Appeal Decision

Appeal Ref: APP/A2525/W/16/3163427

**Ashtree Farm, 92 Guanockgate Road, Sutton St Edmund, Spalding,
PE12 0LU**

- The appeal is made under section 78 of the Town and Country Planning Act 1990 against a refusal to grant planning permission.
 - The appeal is made by Mr & Mrs M Ward against the decision of South Holland District Council.
 - The application Ref H19-0782-16, dated 3 August 2016, was refused by notice dated 17 October 2016.
 - The development proposed is a barn conversion.
-

Drawing
FLOOR PLANS & ELEVATIONS - EXISTING
LOCATION PLAN - EXISTING

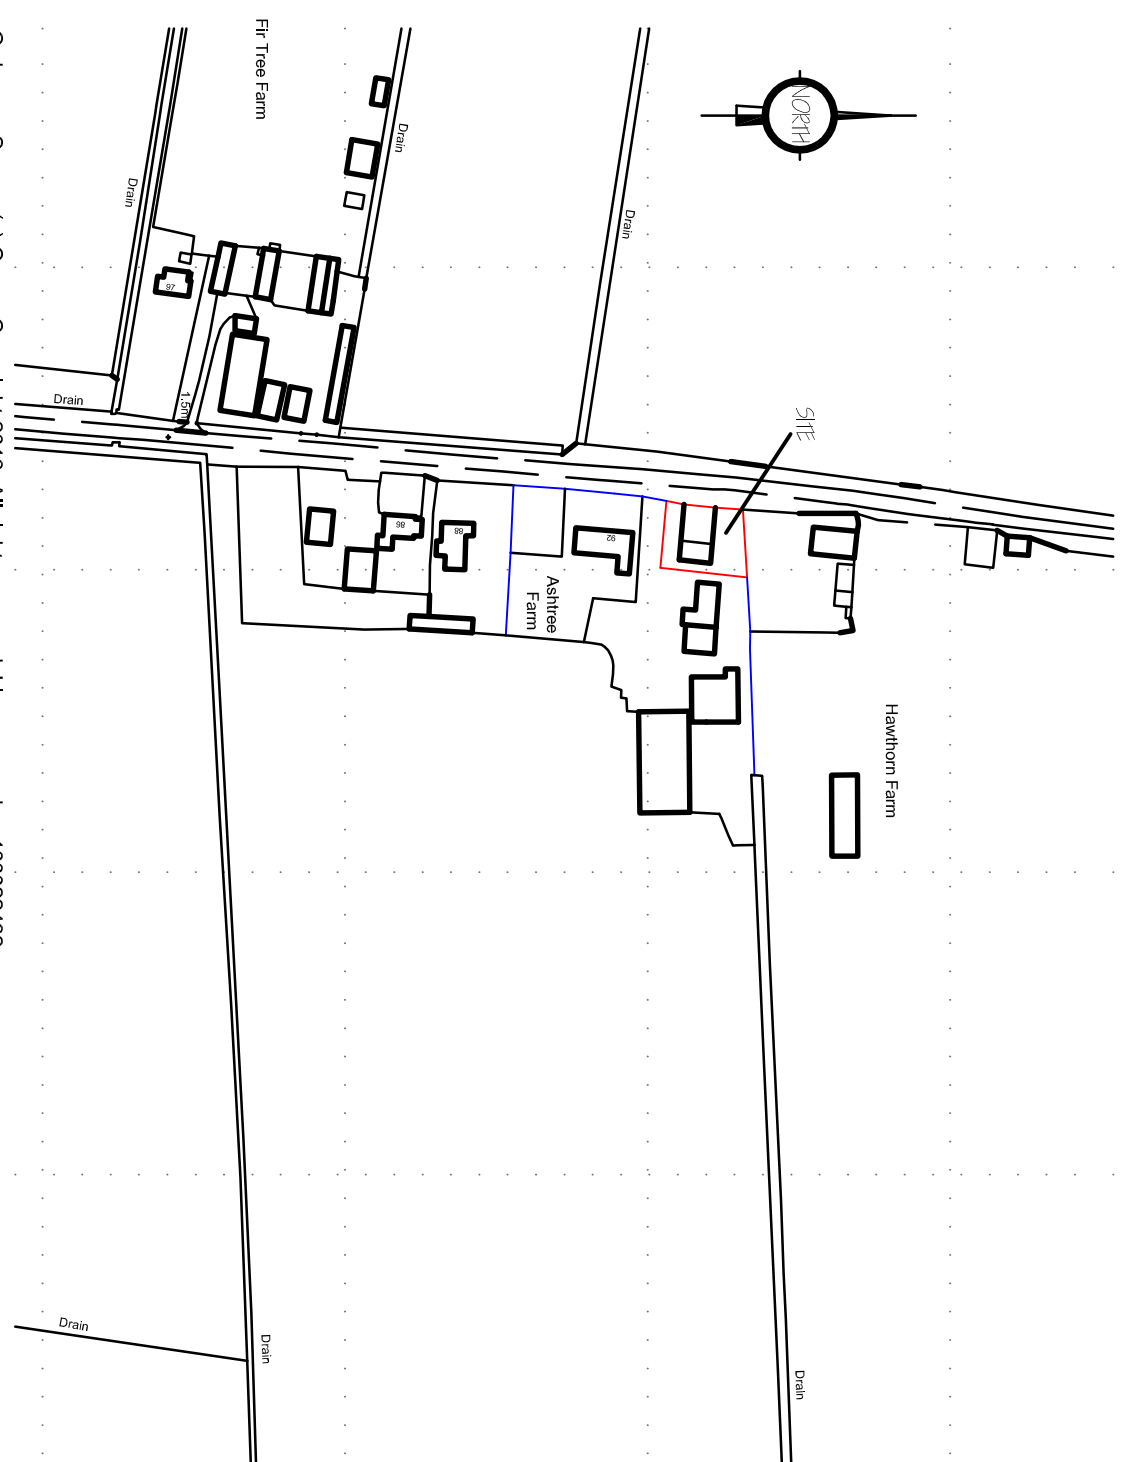
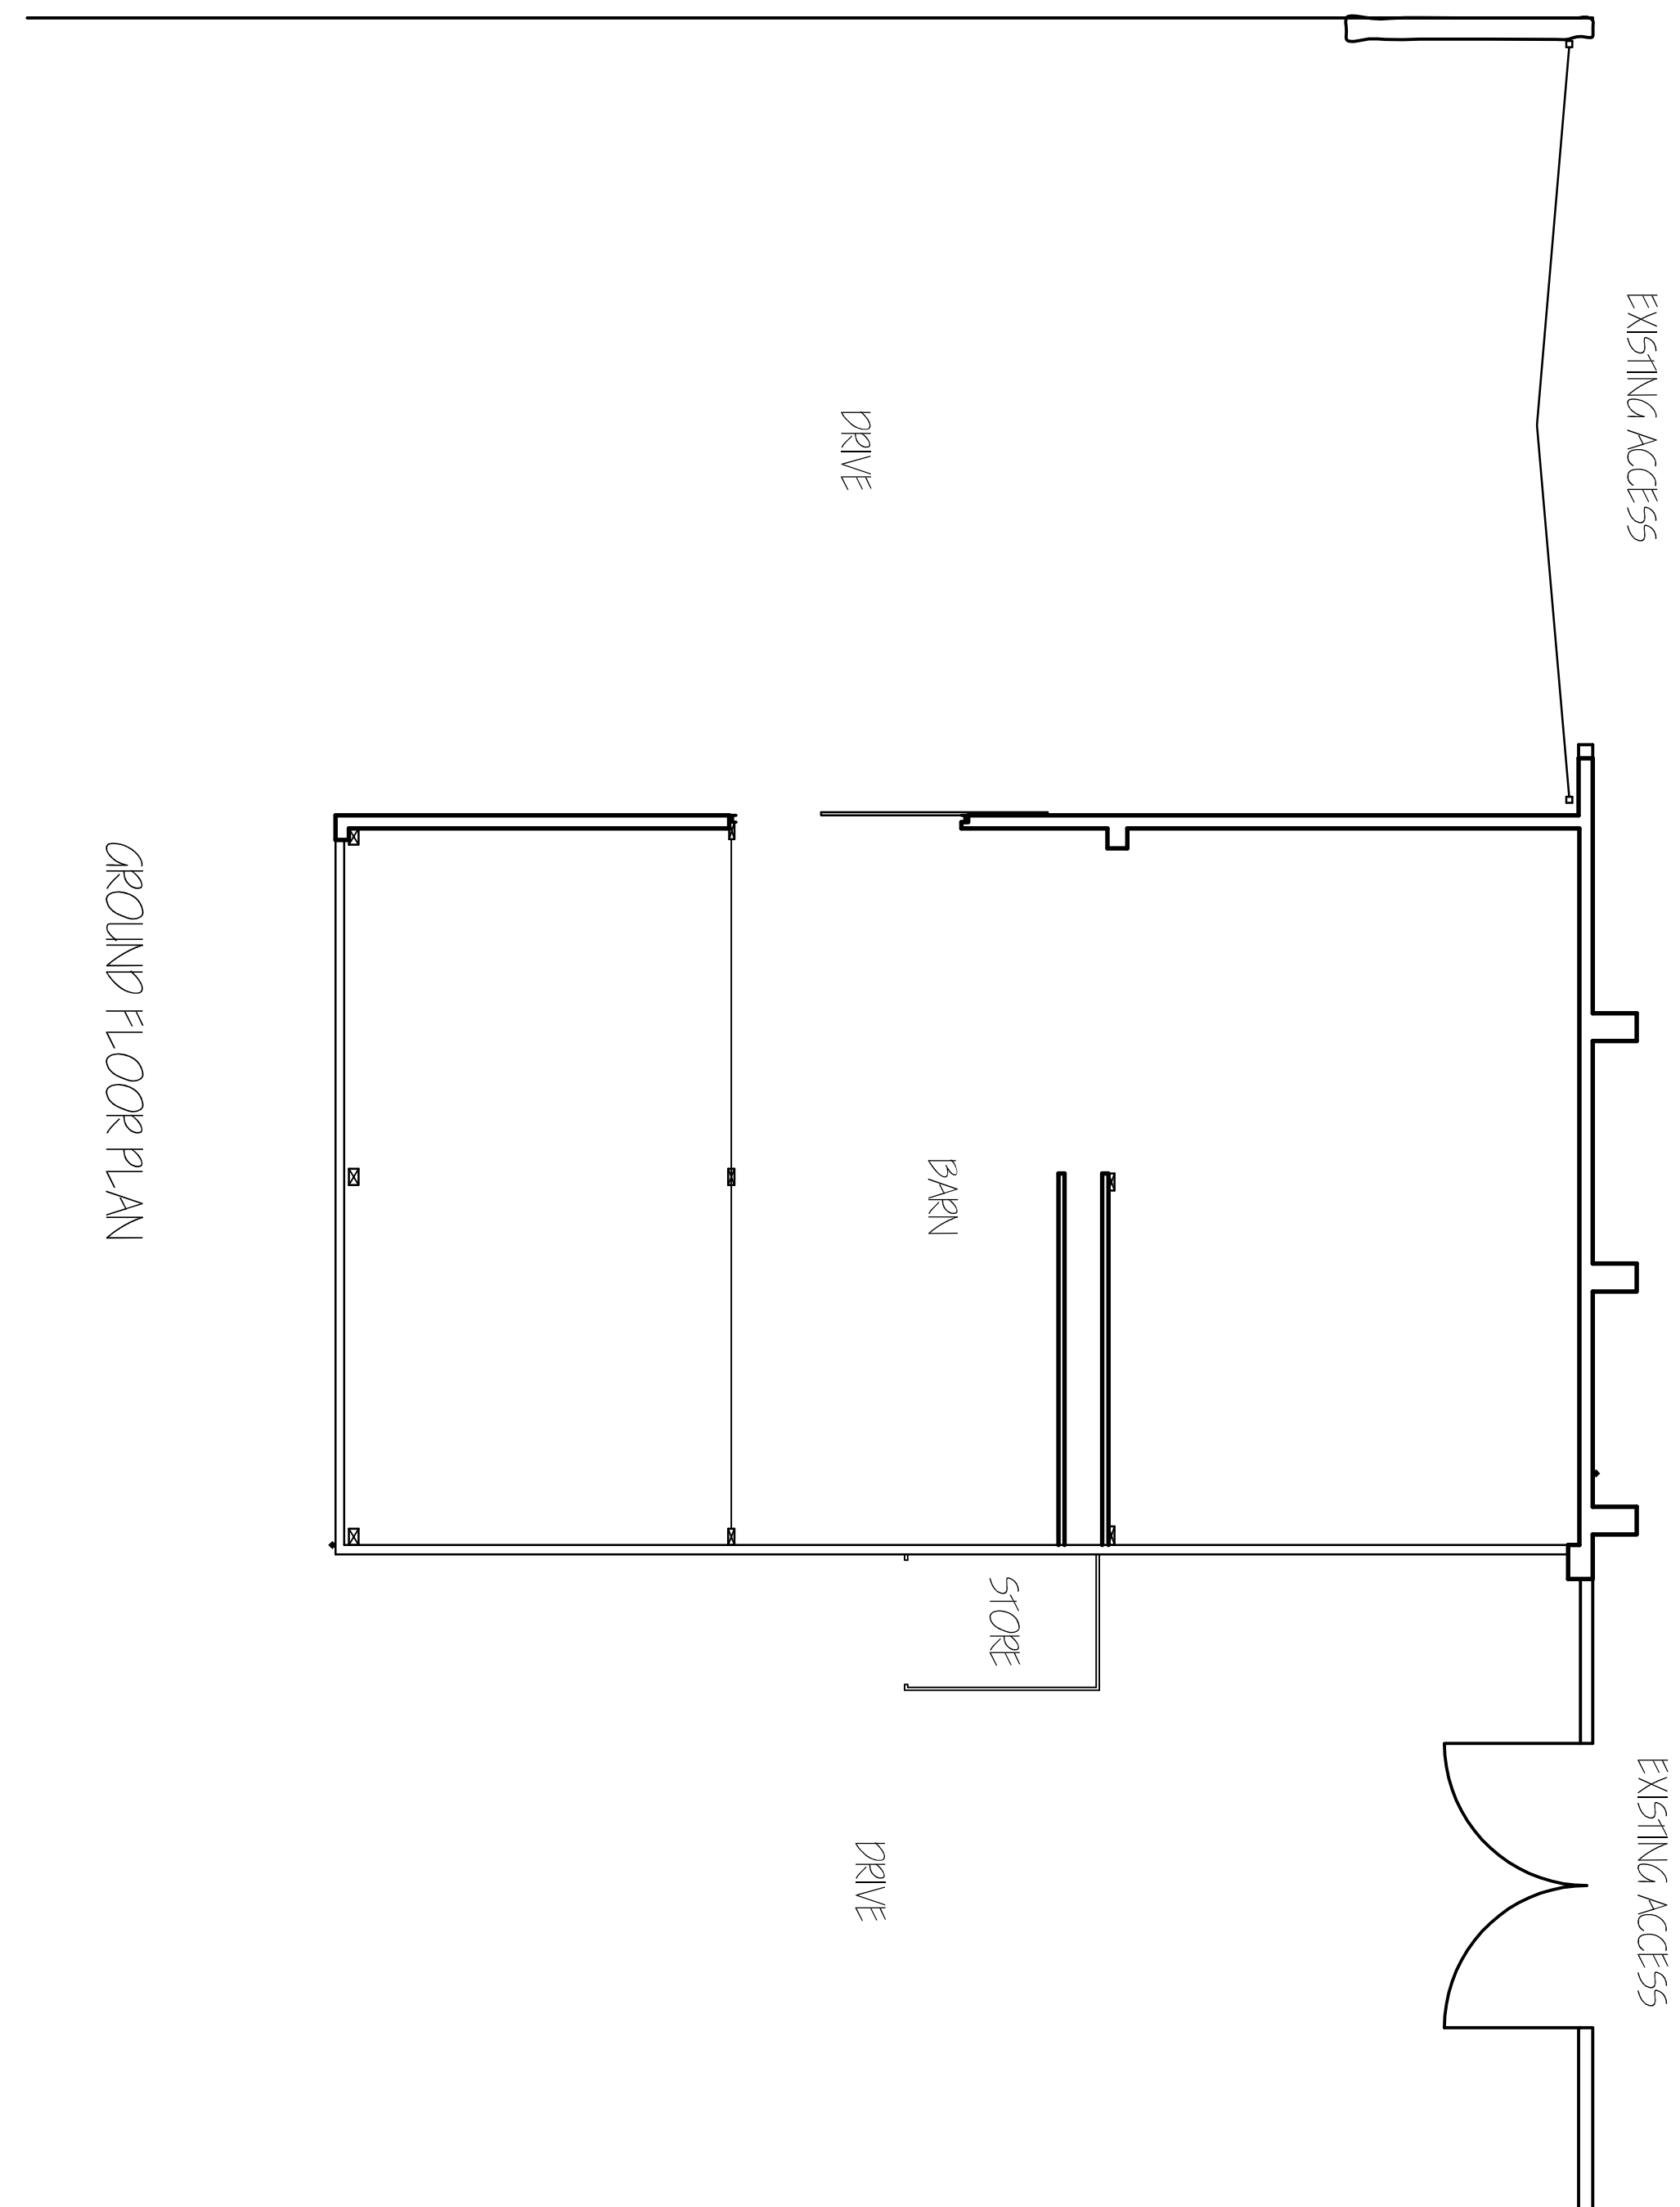
5. The appeal barn is a large rectangular structure constructed from brick and metal grain walling. It also partly clad in asbestos and has an asbestos sheet roof which is pitched. It is located adjacent to Guanockgate Road, and due to
-

6. While its design is fairly typical of modern agricultural buildings, due to its utilitarian form and materials, I consider that the building has no architectural merit and has no positive effect on the rural landscape character. In this respect the principle of the development of the appeal barn would not accord with criterion 3 of saved LP Policy HS16.

FRONT ELEVATION

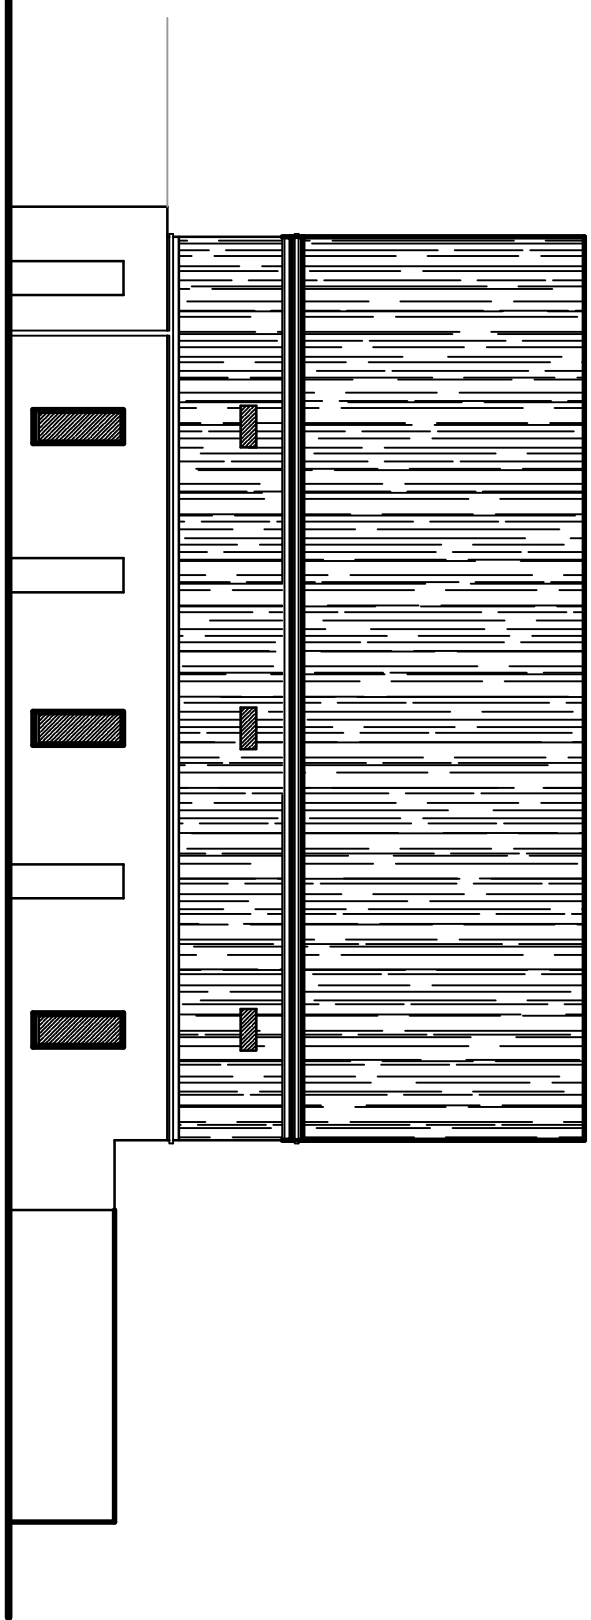
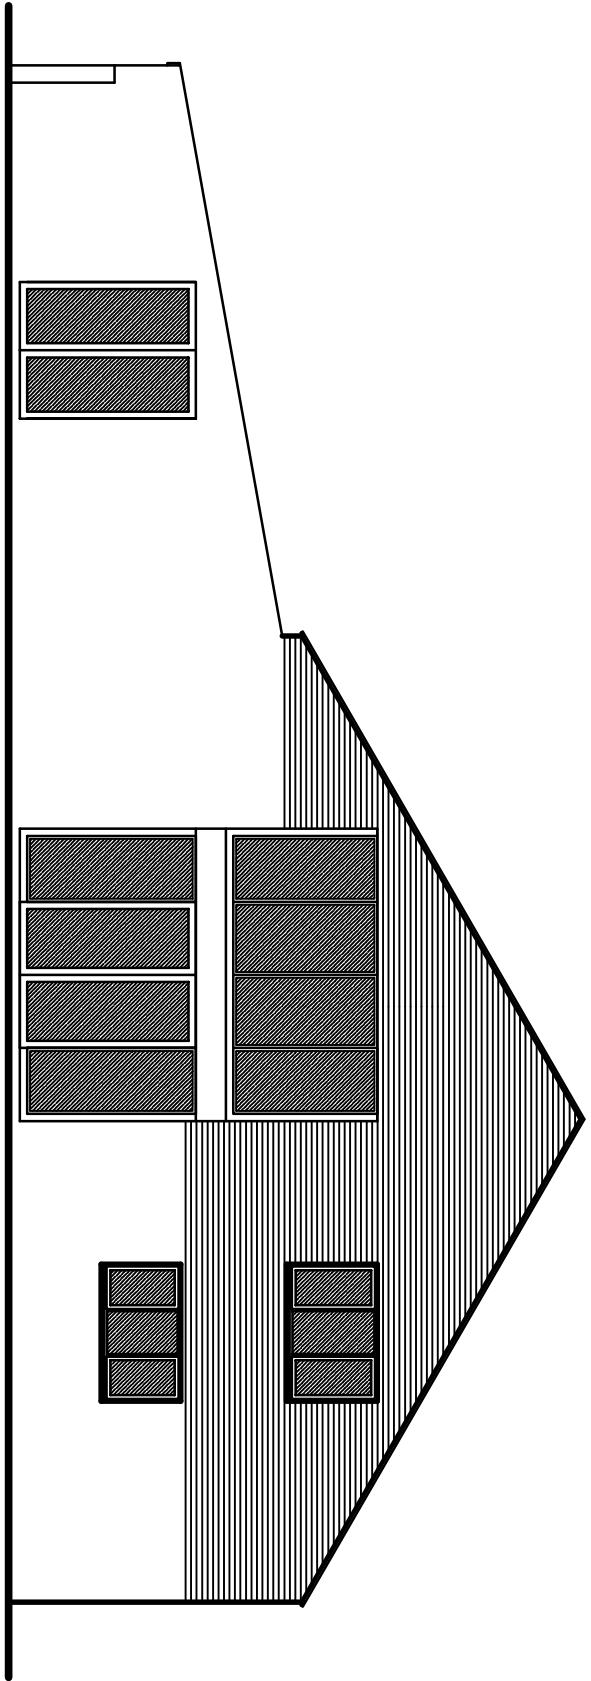
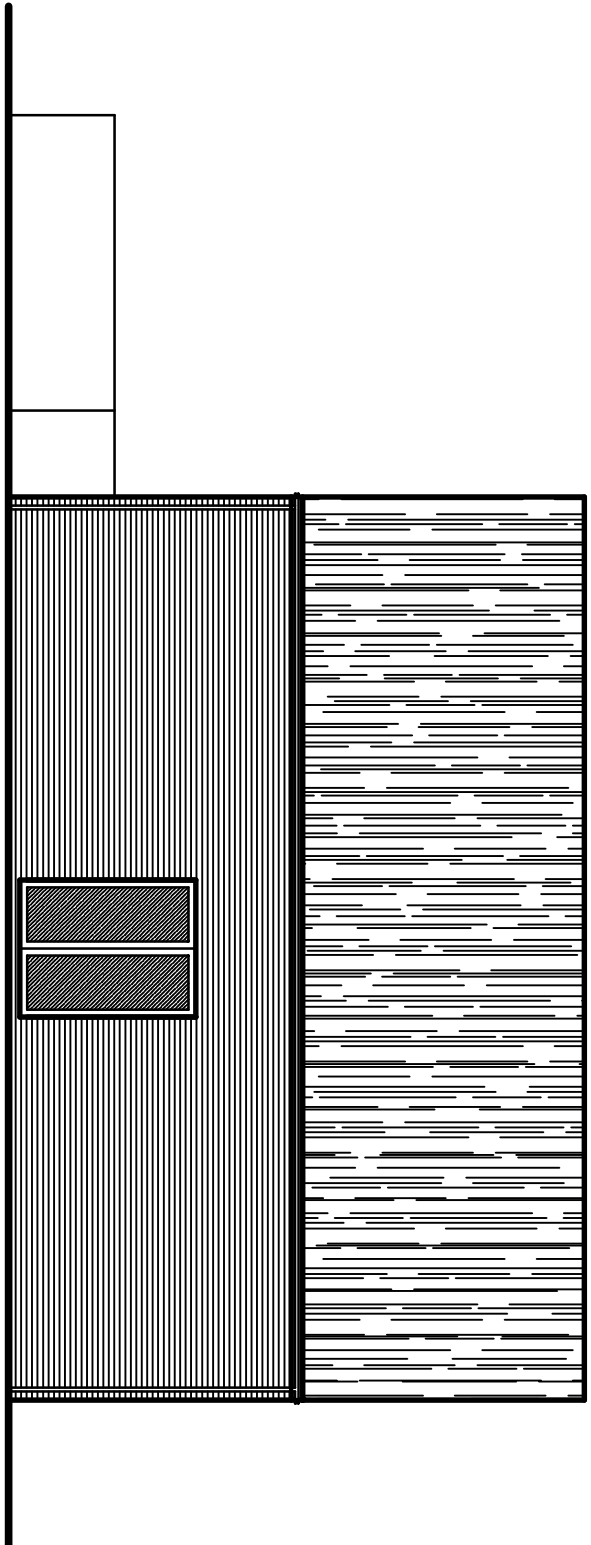
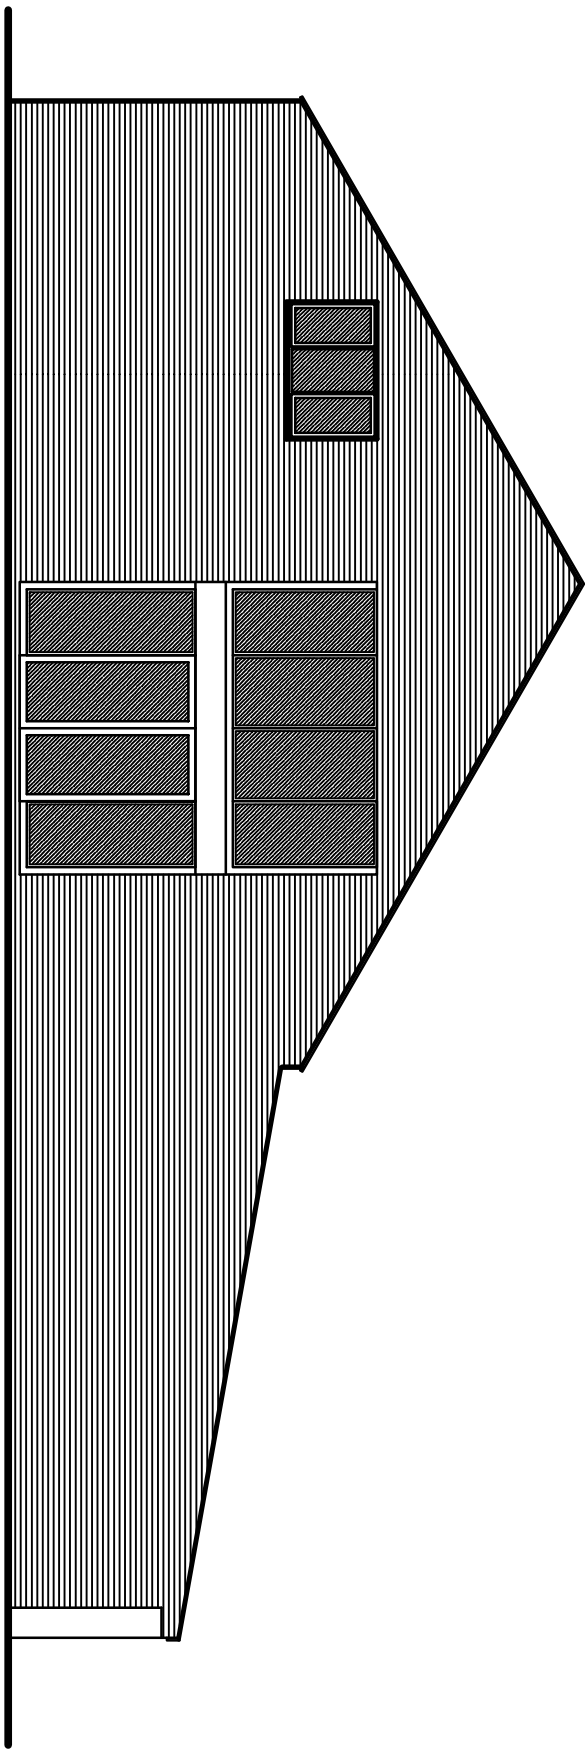
7. Furthermore, in order to convert to a residential use, a number of alterations are proposed. Specifically, the asbestos cladding and metal grain walling would be replaced with brickwork to match the existing, as well as timber cladding. The existing asbestos sheet roof would be replaced by natural slate and the pitch and height of this would be increased to allow accommodation at first floor level. Timber windows and doors would be inserted where there are large existing openings and a number of new openings to each elevation.

8. I find that these alterations would be significant. I note that the aim of the design is to enhance the external appearance of the barn, however, the introduction of a number of windows and timber cladding would dramatically change the appearance of the barn and I consider that the development would have a domestic character. Moreover, while I note that the footprint of the barn would remain the same, the upward extension would further increase the prominence of the barn in the rural landscape. The development would not therefore accord with criterion 4 and 5 of LP Policy HS16 which relate to extensions and design of rural buildings.
